PLANNING AMENDMENT

Application No. H11/0636/97
Date Registered 24 JUL 1997
Case Officer

Description: Erect detached double garage

Amendment: Reposition garage on site
(Drawing No. 771952/1)

SITE PLAN

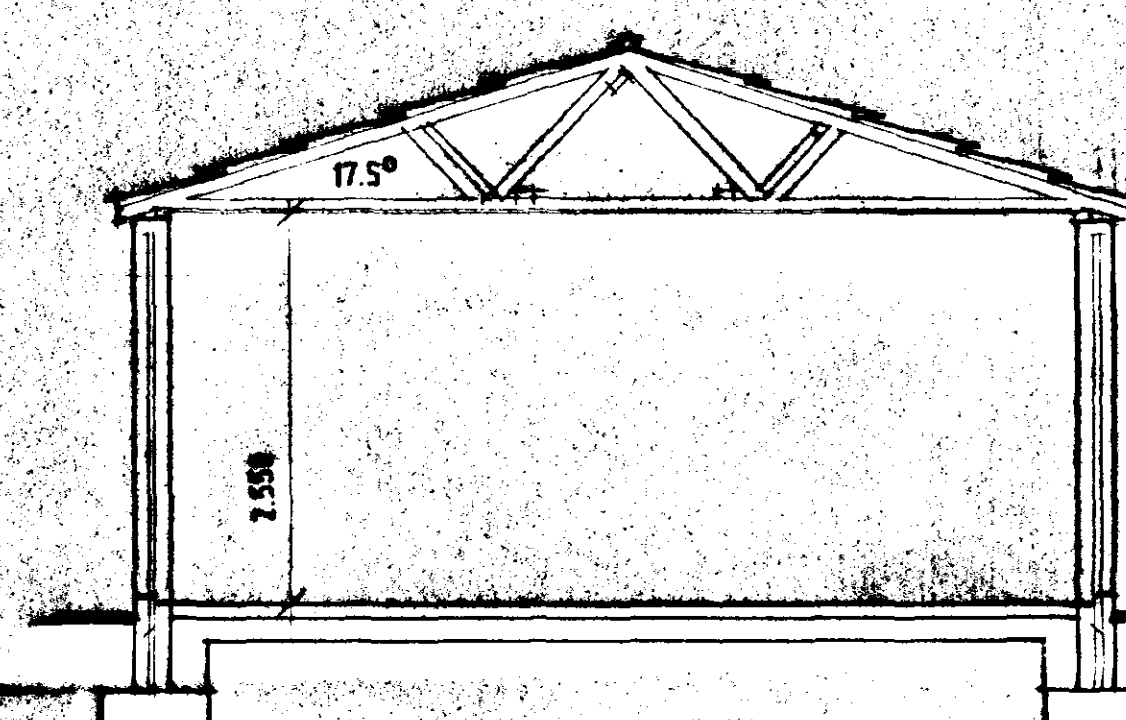
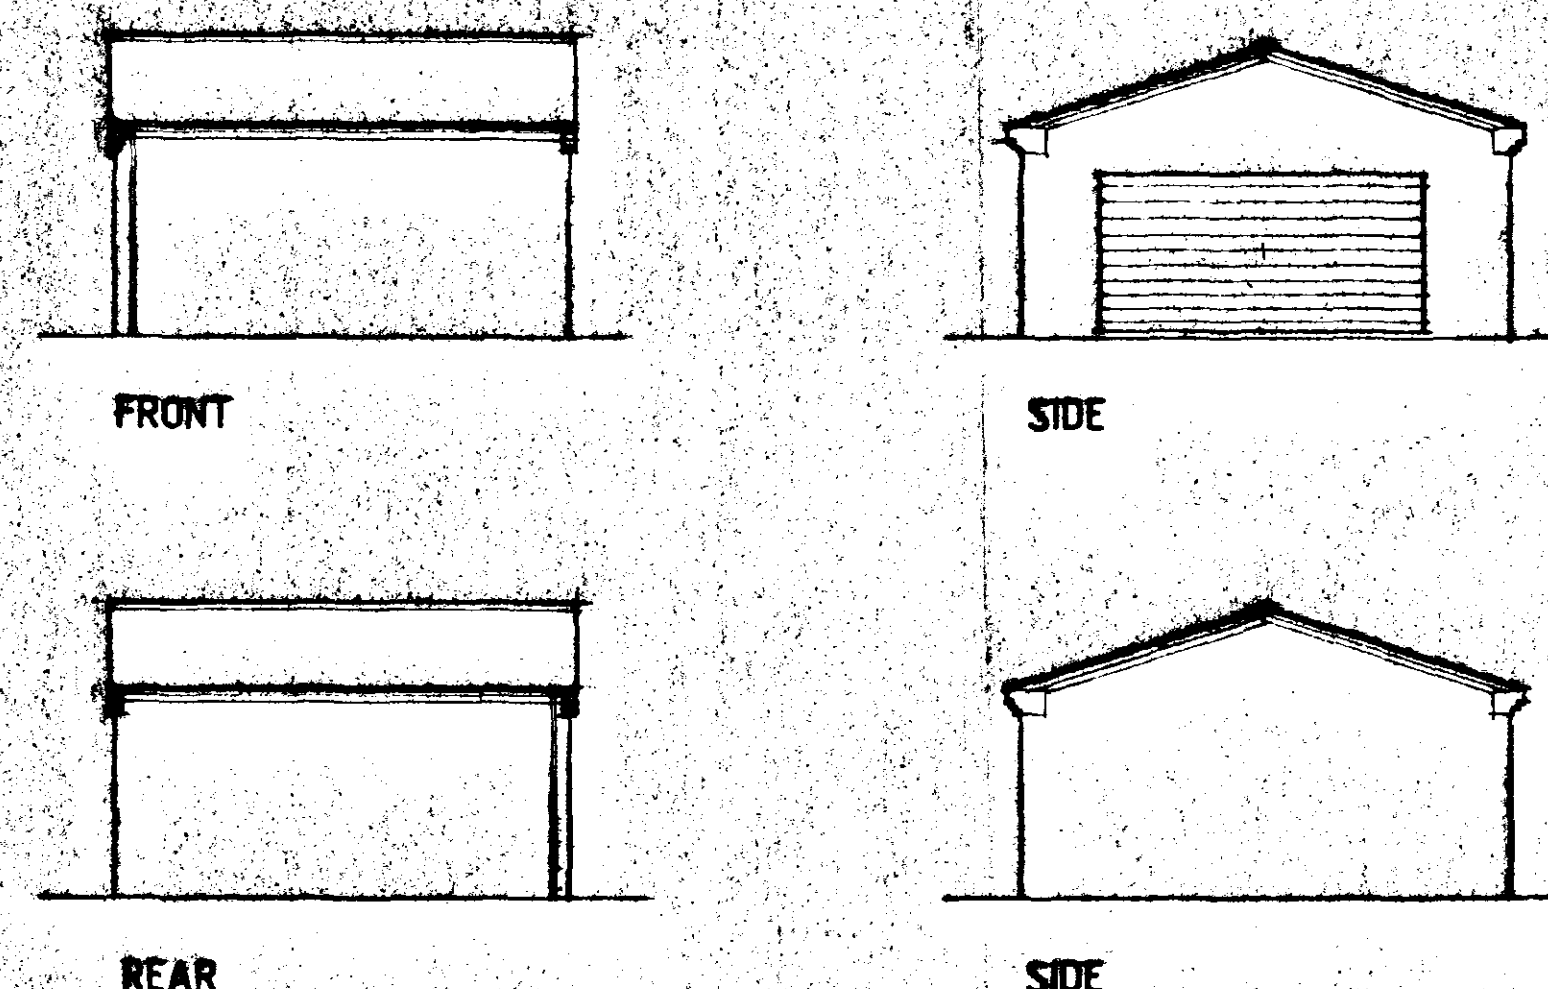
REPOSITIONED ON SITE
